Town & Country Planning Act 1990 (as amended)
Town & country Planning (Development Management Procedure) (England) Order 2015
Application for Planning Permission for Works or Extension to a Dwelling

Development Single storey rear extension, single storey front/side infill extension & removal of entrance porch at front.

Location 98 Elmer Road Middleton on Sea

Block Plan Amend

No. 14/18/03

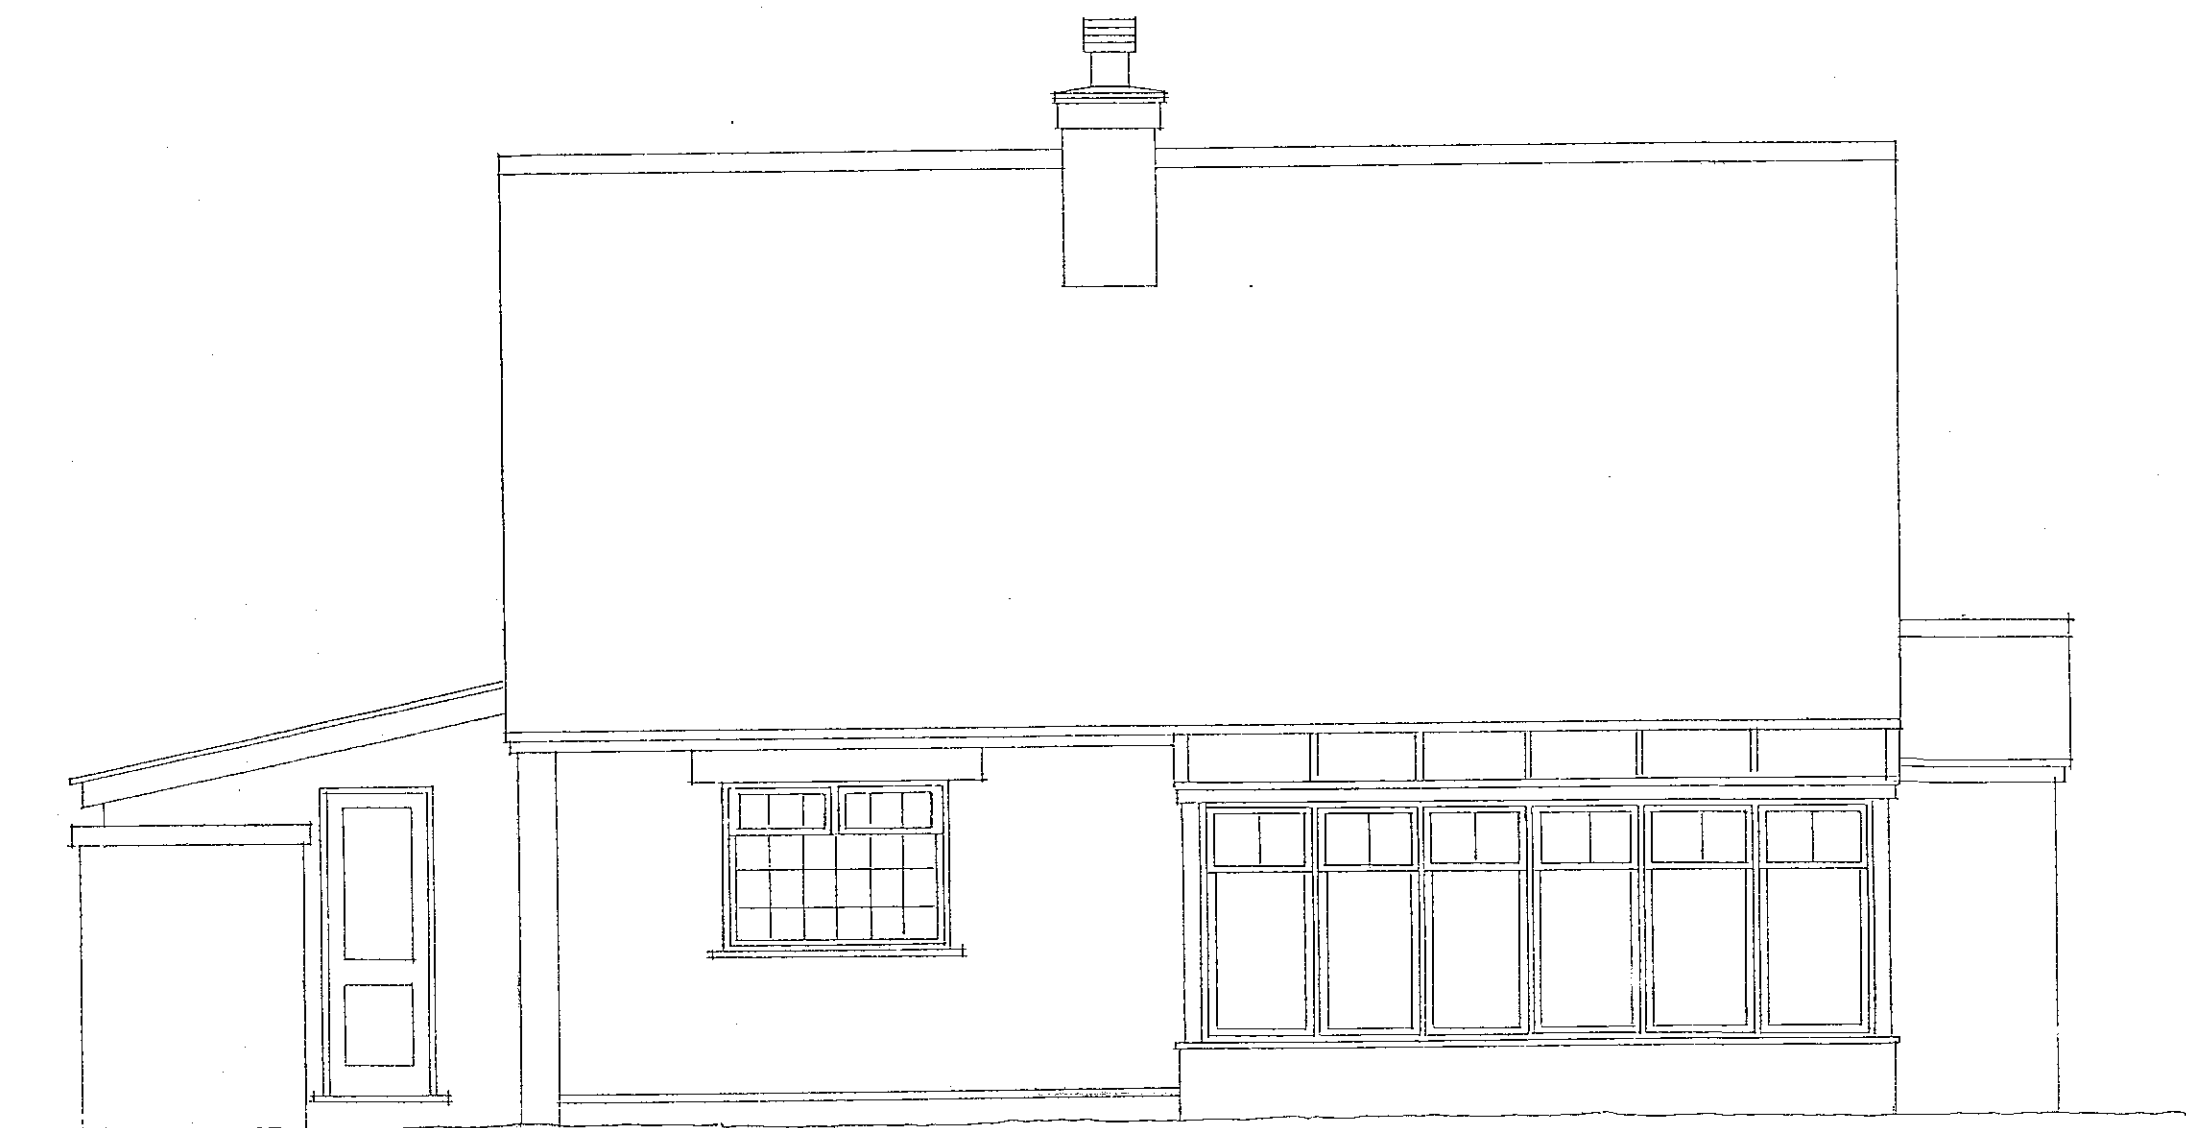
The existing ground floor plan and elevation do not accord. Please amend accordingly.

No. 14/18/06

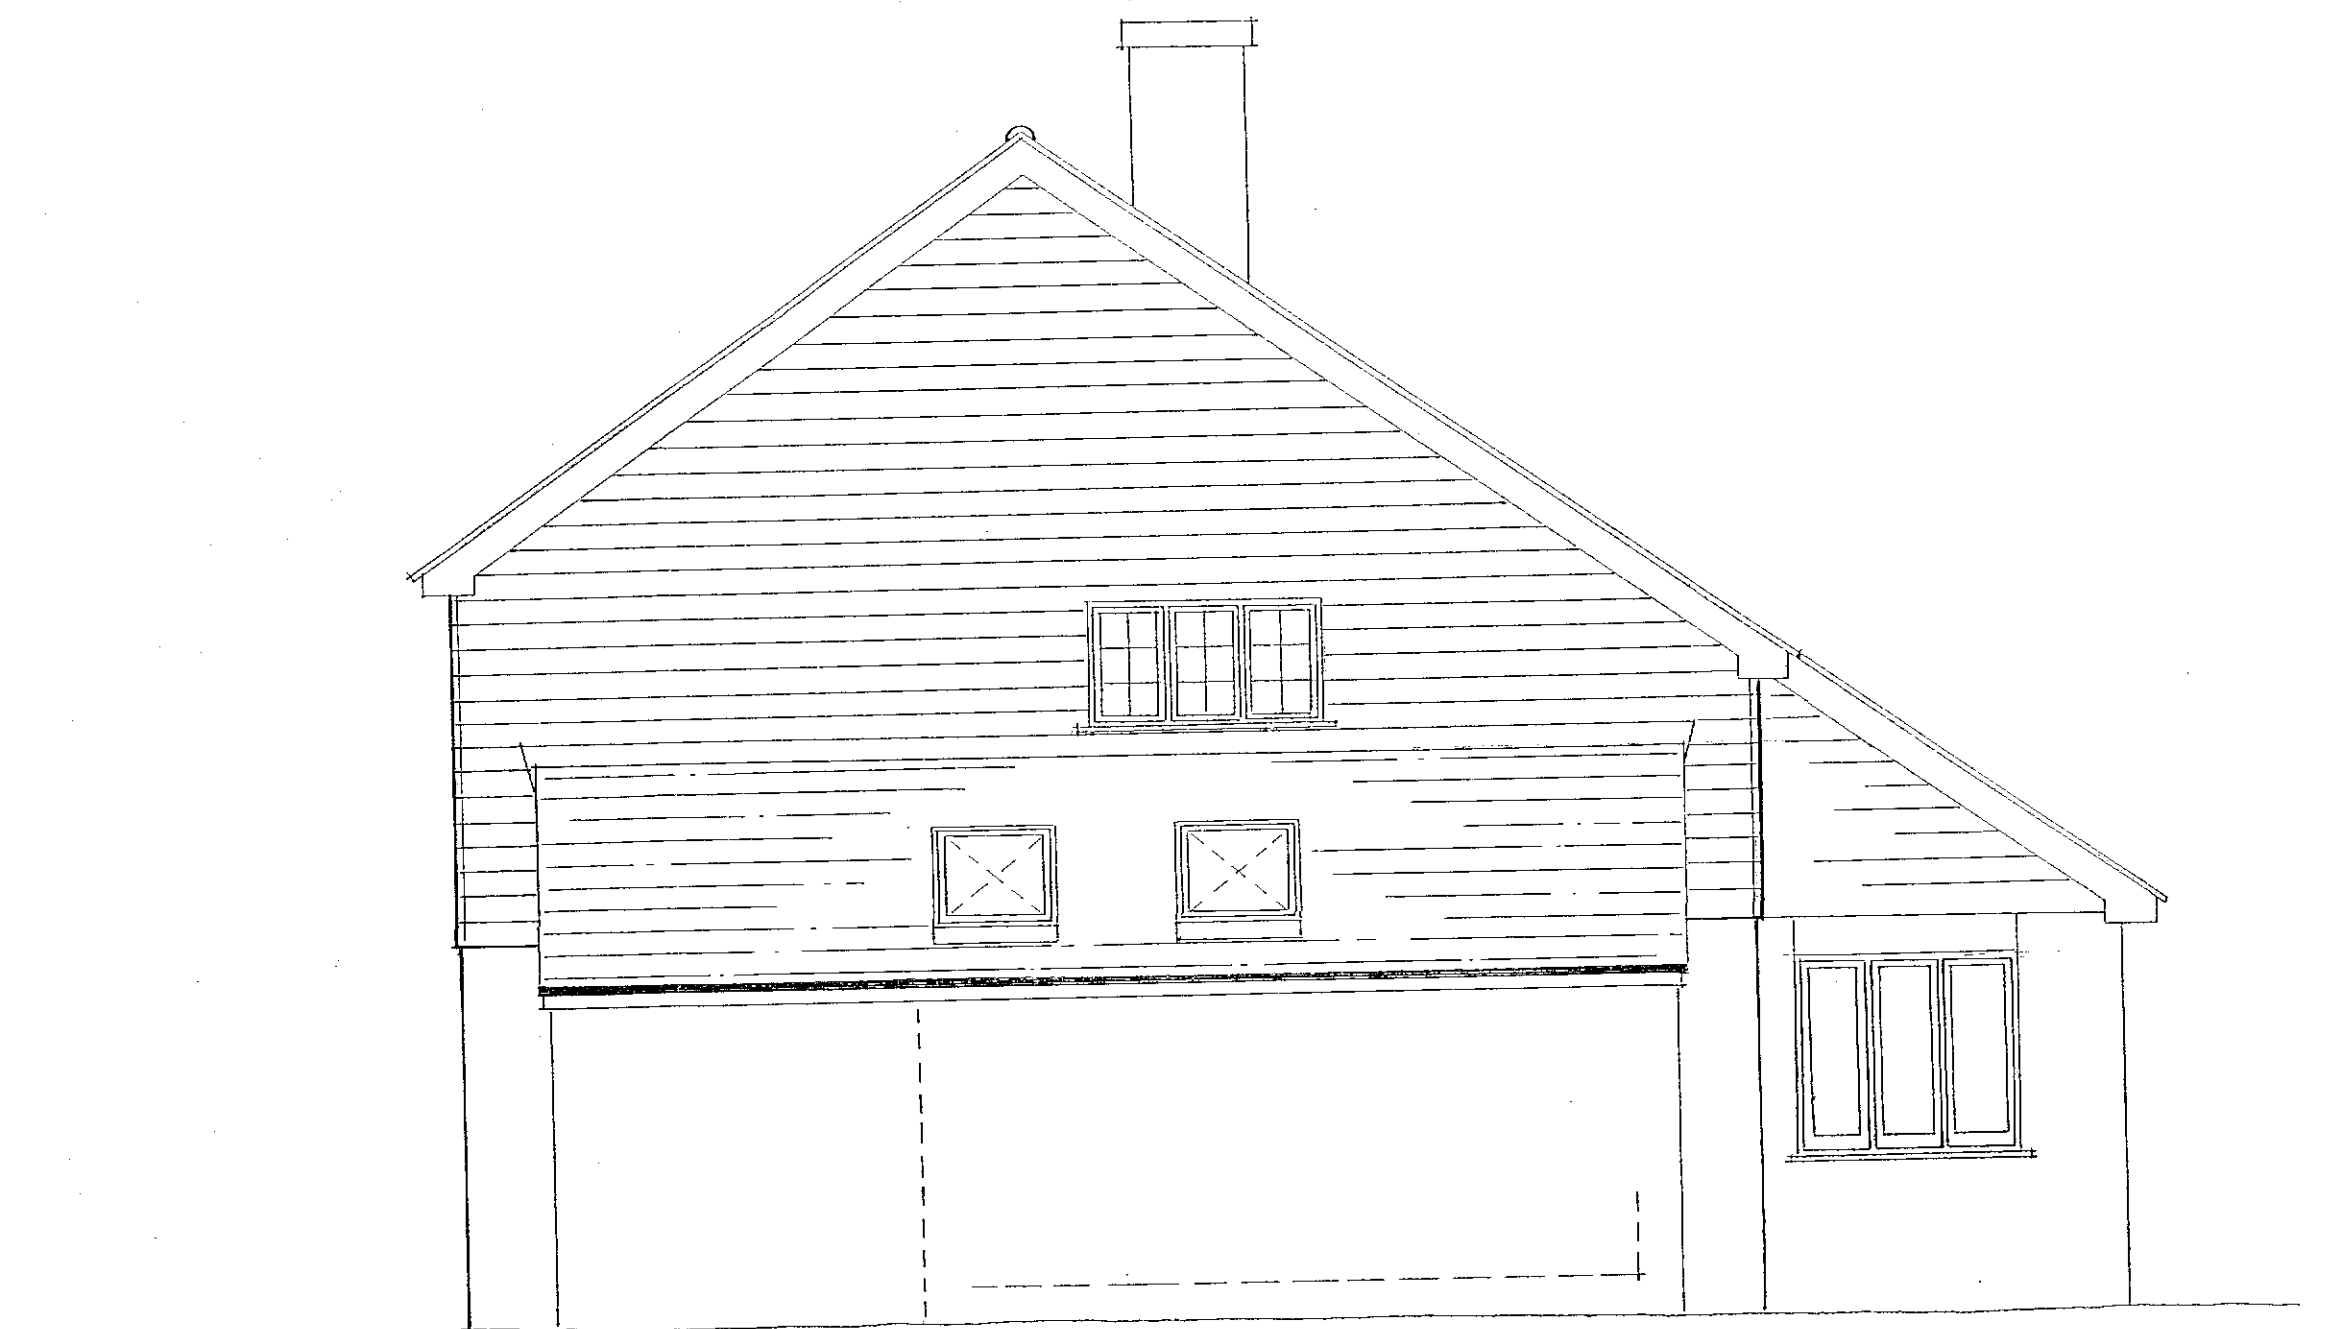
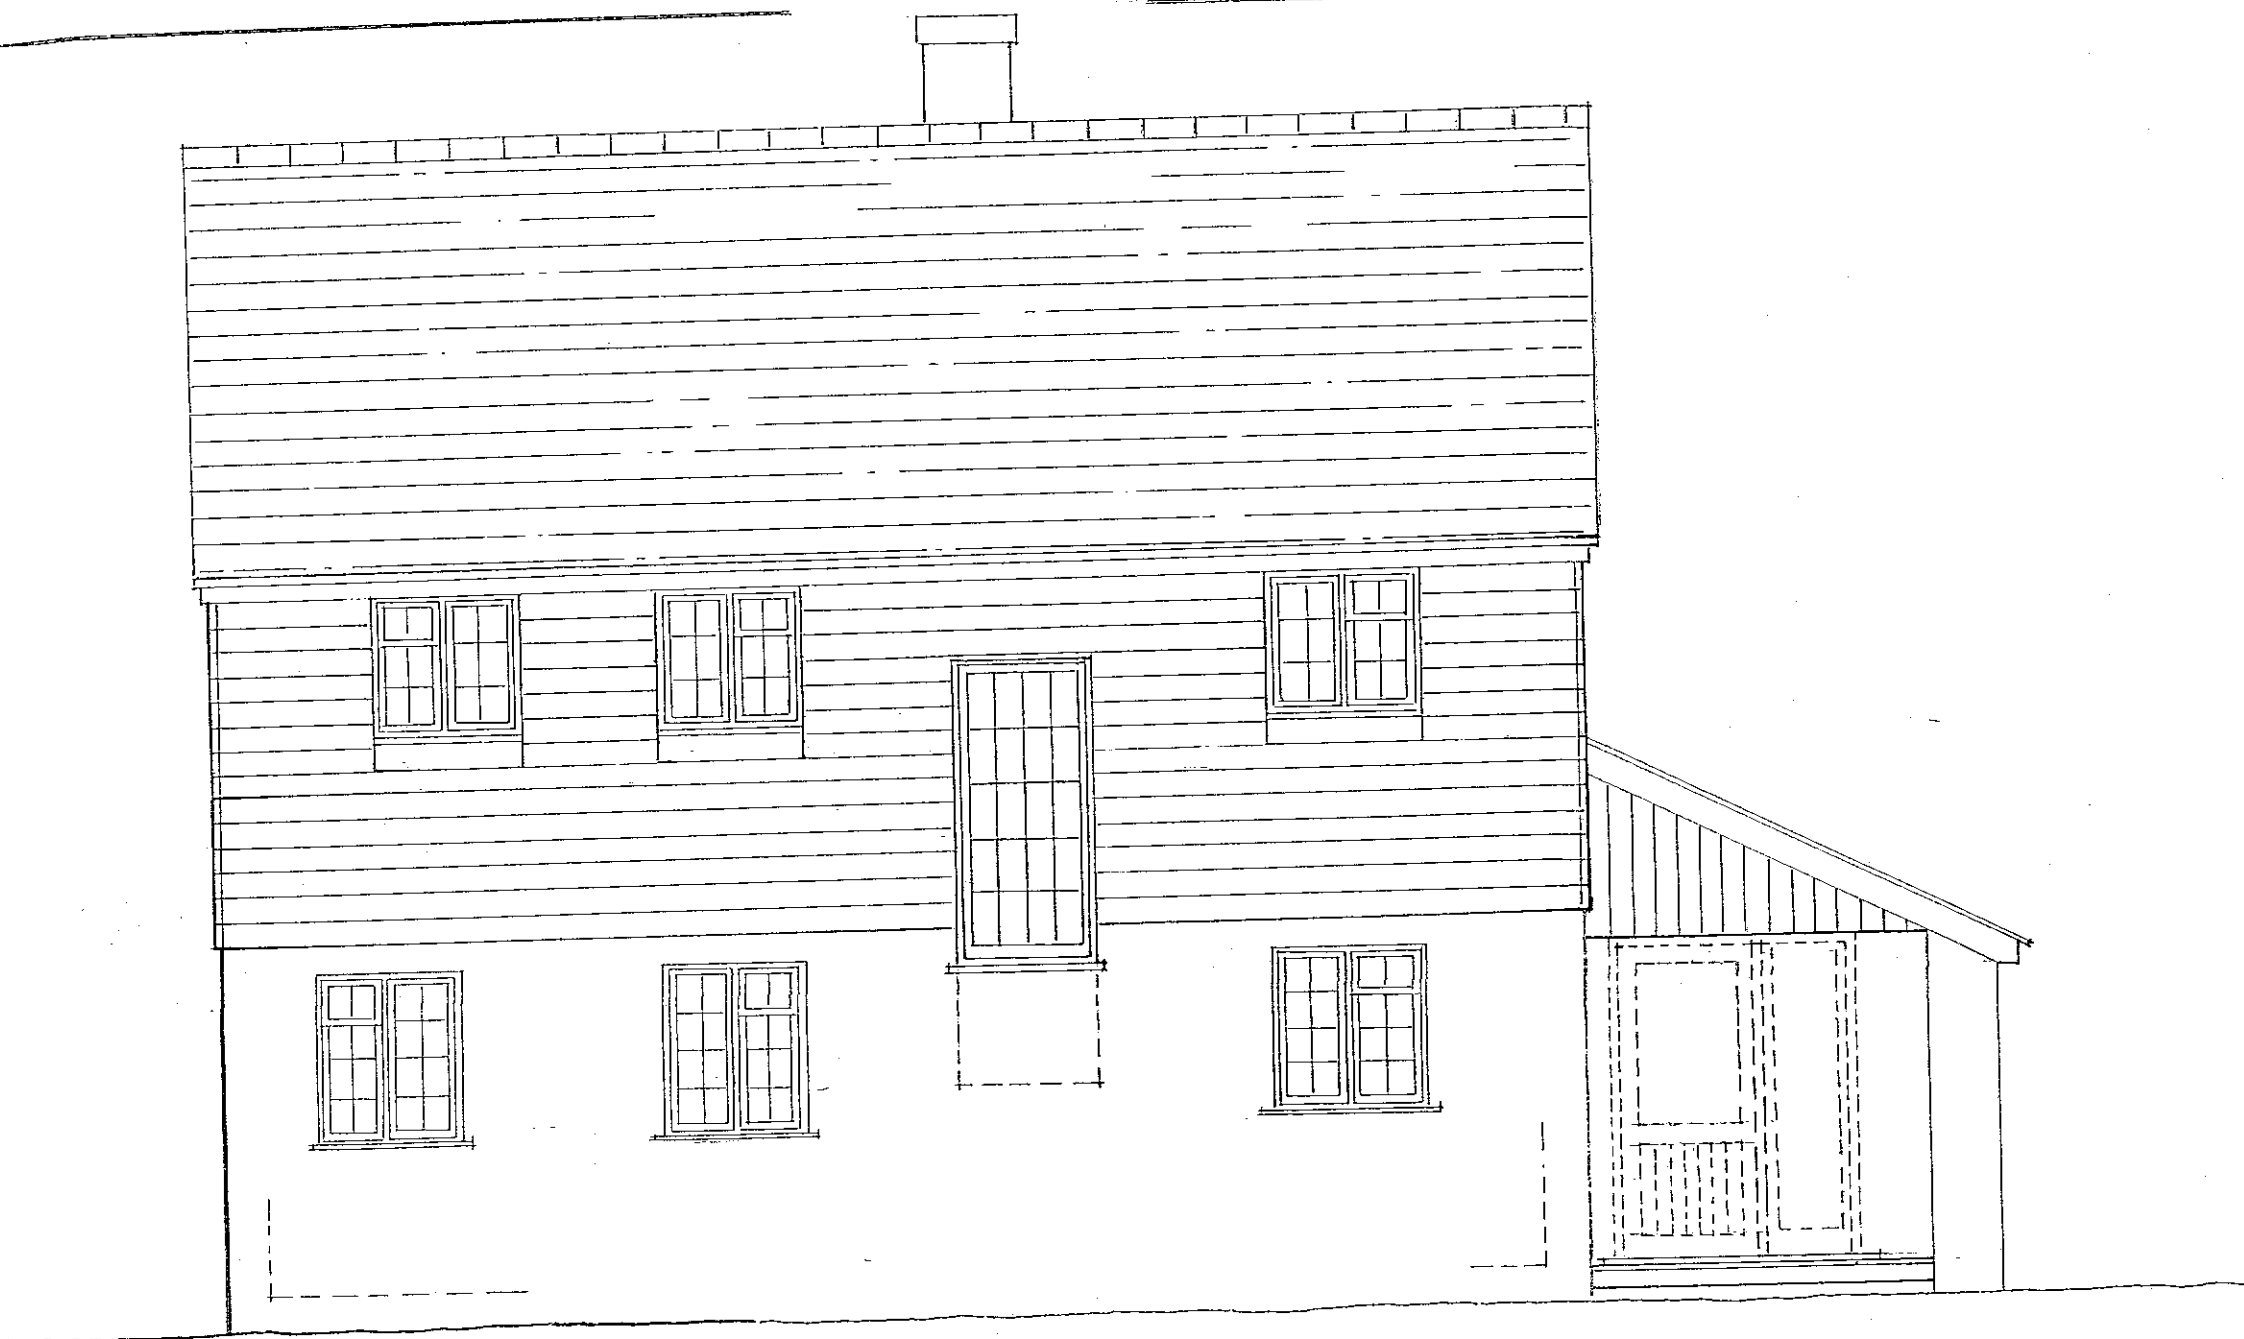
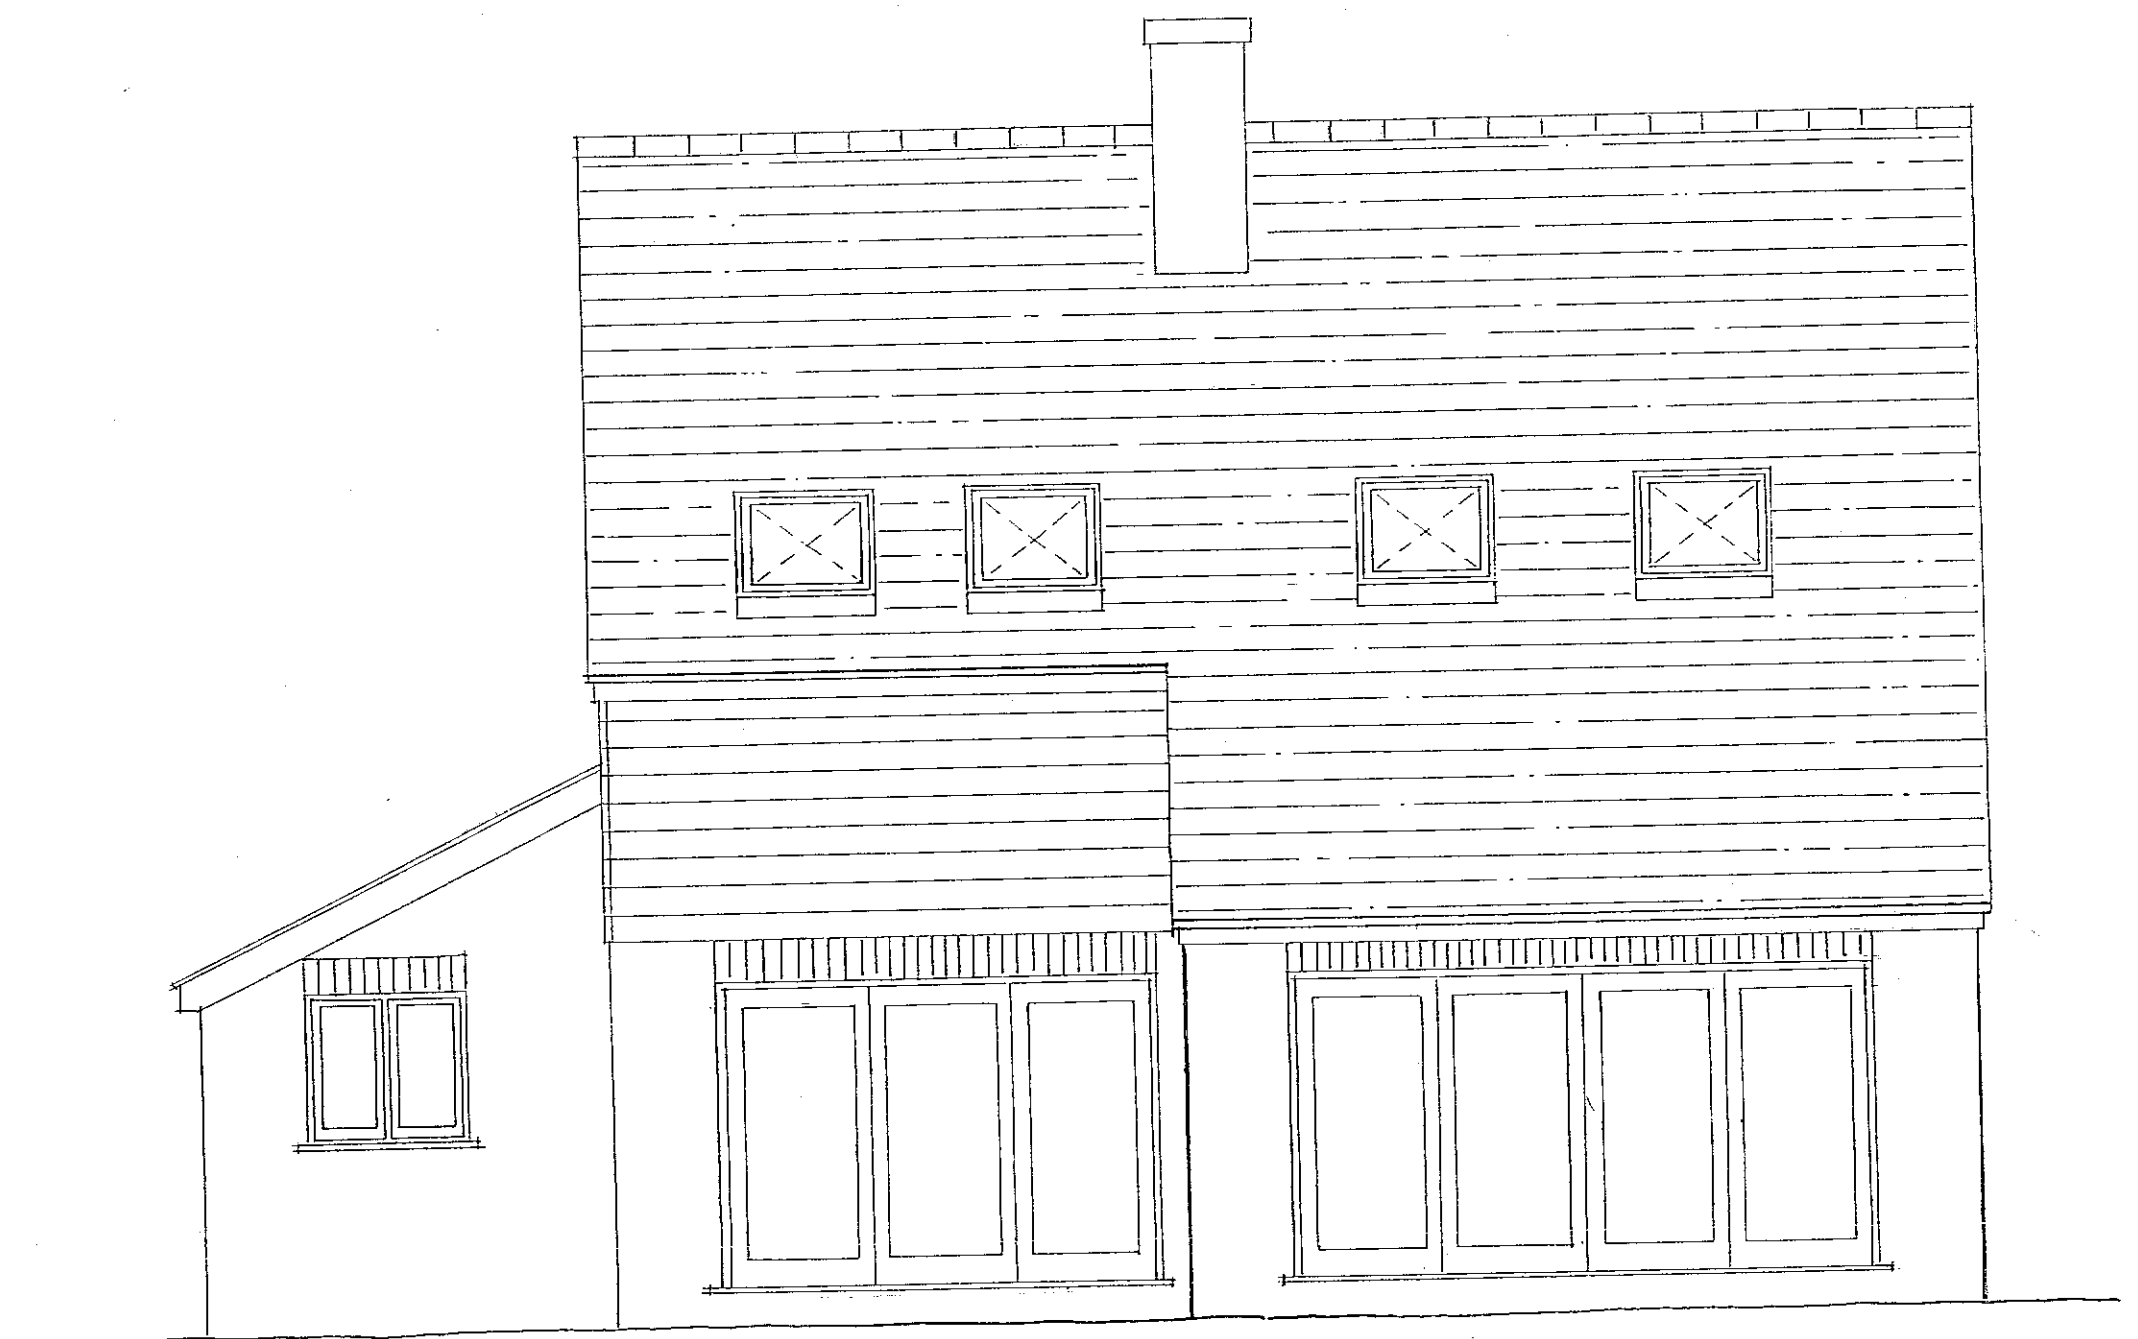
Two sets of existing elevations have been provided. Please relabel the appropriate elevations as proposed and label all elevations as front, back or side.
